From: [Martin Chambers](#)
To: [Mona Offshore Wind Project](#)
Cc: [REDACTED] [@m3wind.com](#); [Laura Leigh](#); [Ellie Dakin](#); [Neil Roberts](#)
Subject: Deadline 7: Tan-y-Mynydd Fishery response to Hypothetical Hydrgeological Risk Assessment Report (HHRA)
Date: 13 January 2025 11:00:37

Feedback on Hypothetical Hydrogeological Risk Assessment (HHRA)

Report Ref: S_D6_8

Document Number: MOCNS-J3303-RPS-1042

Figure 8: Schematic groundwater recharge catchment area, showing the Onshore Cable Corridor and the Tan-y-Mynydd Trout Fishery

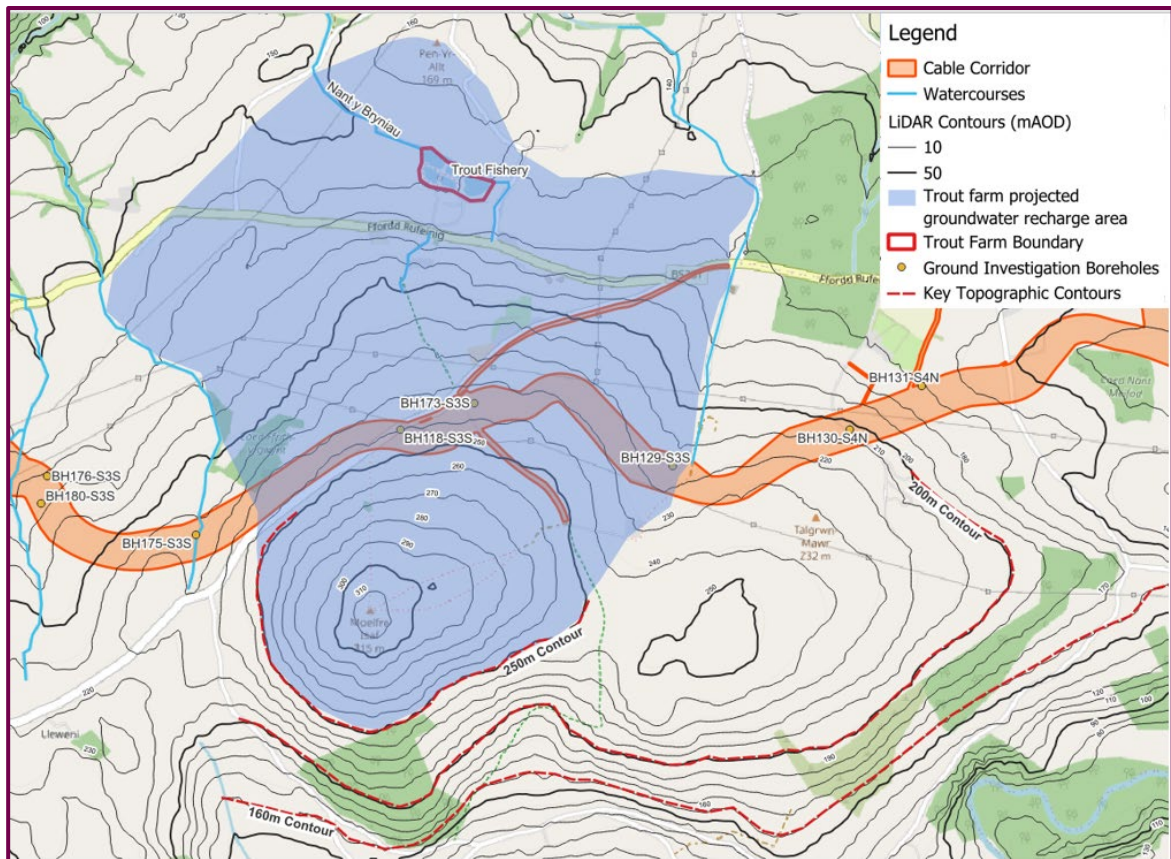
Section	Page	Para	Observations / Comments	Note
3. Site Setting	21	3.4.3.2	We consider that Figure 8 is highly optimistic in its representation of the potential extent of the recharge catchment area. The area to the north of the fishery has previously been discussed and discounted. However, in addition the areas of land to the east and west of the highlighted indicative catchment area do appear more likely to serve the other water courses shown as adjacent to them and not those springs serving the fishery. We therefore consider that the highlighted area (shaded in blue within Figure 8) to be some 60% larger than might reasonably be expected to actually serve the fishery.	See attached marked up figure 8
	23	3.5.1.3	The 70m vertical separation again fails to recognise the elevation at which the spring serving the brook on the south boundary of the fishery emerges above ground.	
	24	5.5.1.4	Figure 10 is highly biased in the way that it purports to indicate the extent of the possible location of the 'highly fractured sandstone unit in the Elwy Formation (ground water bearing)'. There is no evidence provided to indicate why this formation is considered not extend to the route of the cable corridor.	See attached marked up figure 10
